4 September 2015

SF2013/170831
CR2015/001789
DC

CORMORANT ROAD (B63): CAR WASH FACILITY (DA6988), 130 CORMORANT ROAD,
KOORAGANG

Approved	Designed
Date 2nd OCTOBER 2014	Drawn AST
Scale 1:200 @ A1, 1:400 @ A3	Checked
Project No. 14 - 056	Drawing No. A - 01
	Andt. DA-4

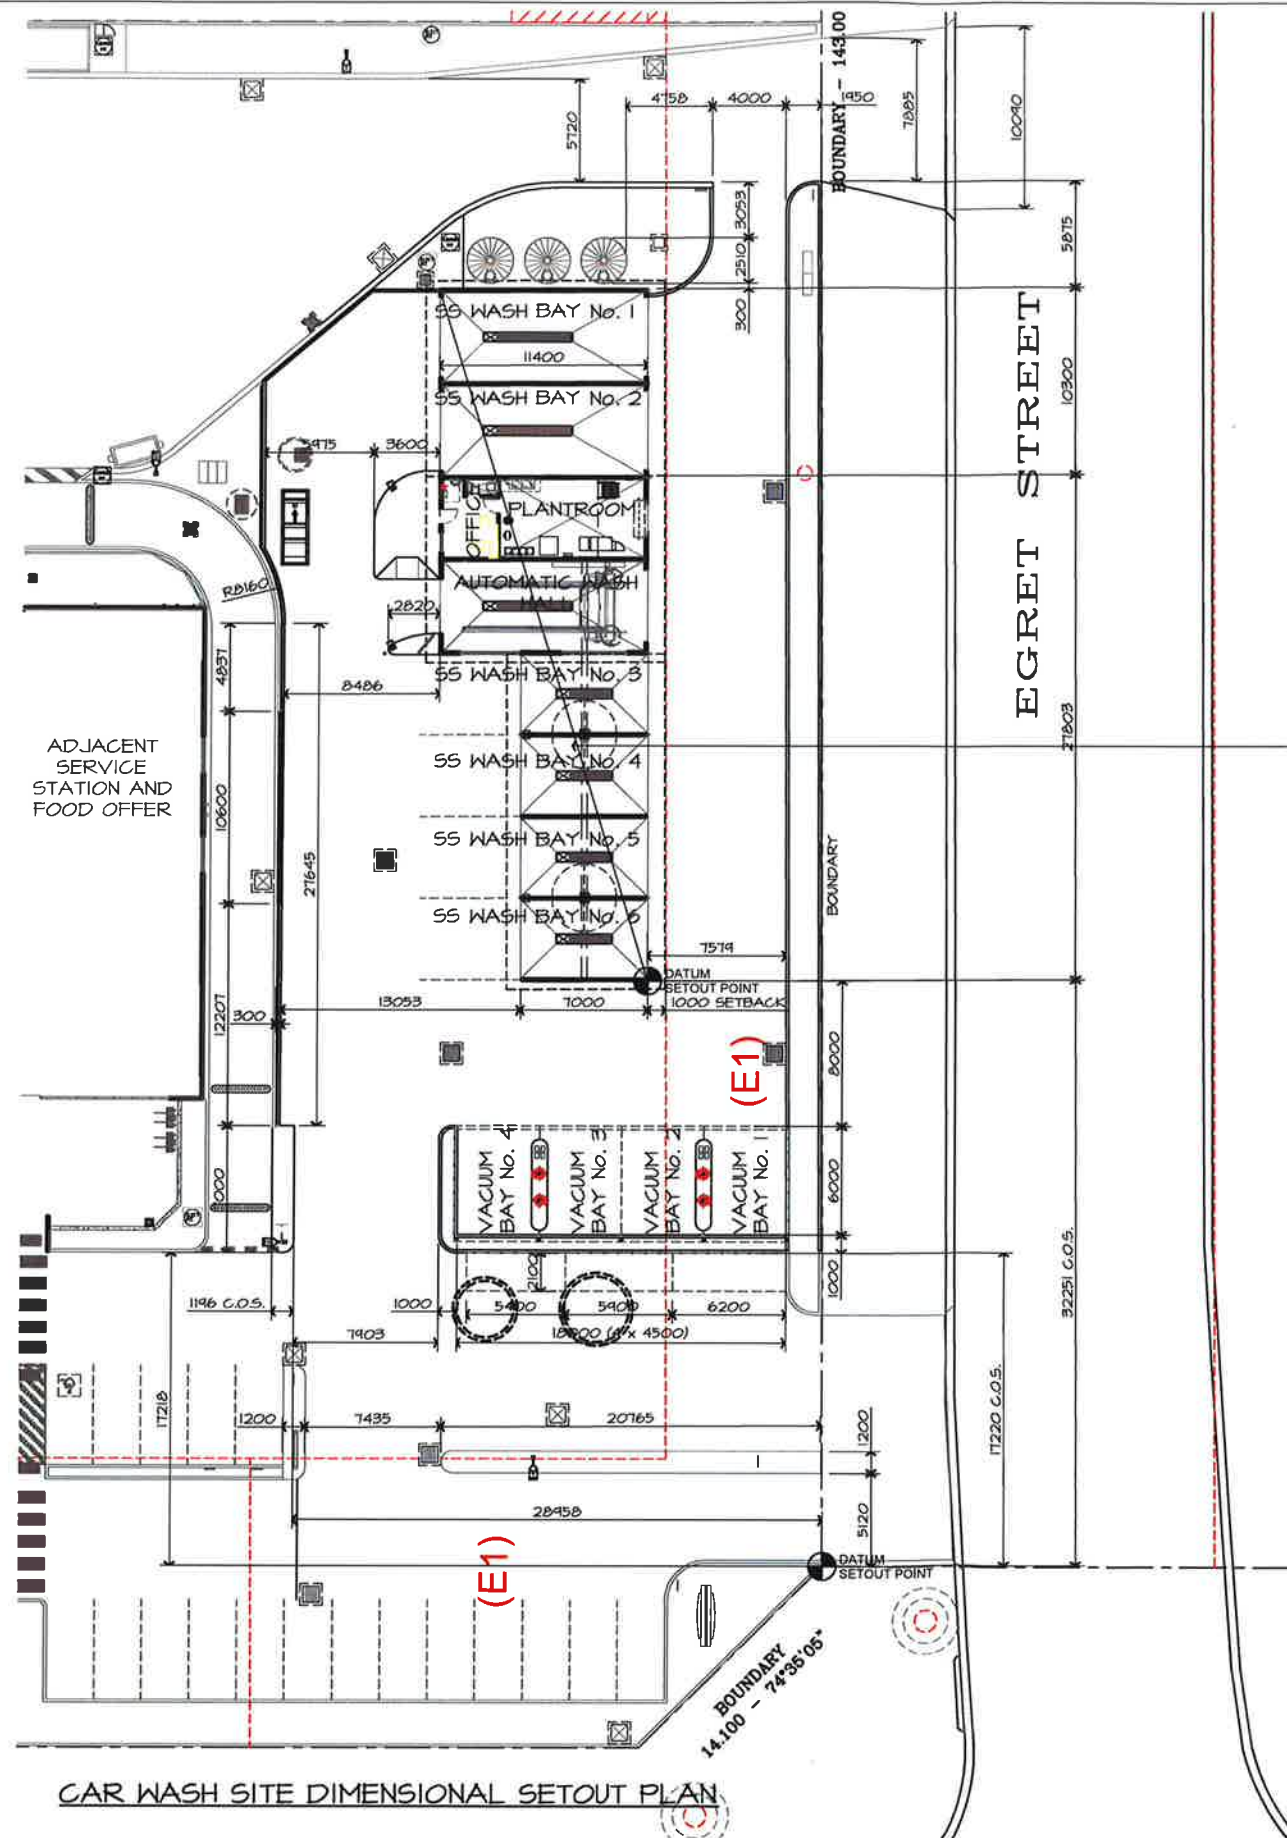
Roads and Maritime note that the current arrangement for entry into the car wash facility has the potential to cause queuing onto Egret Street and could impact Cormorant Road, due to cumulative traffic movements from development and the approved service centre.

- The physical barrier at the entry driveway on Egret Street shall be extended to allow the flow of traffic to enter and turn right along the western boundary of the carwash facility

Comment: This arrangement will increase the storage capacity of vehicles on the site and reduce the potential for queuing onto Egret Street. Attachment A is a strategic plan showing the extent of median considered necessary by Roads and Maritime.

Consideration should also be given to the removal of the two carspaces nearest to the south-east boundary of the site to allow for the safe ingress of vehicles into the development.

Comment: Vehicles entering and exiting the parking spaces nearest to the entry driveway may also impede the safe operation of the driveway and could lead to potential queuing onto Egret Street.

- The type of physical barrier, directional signage and line marking shall be installed in consultation with Council.
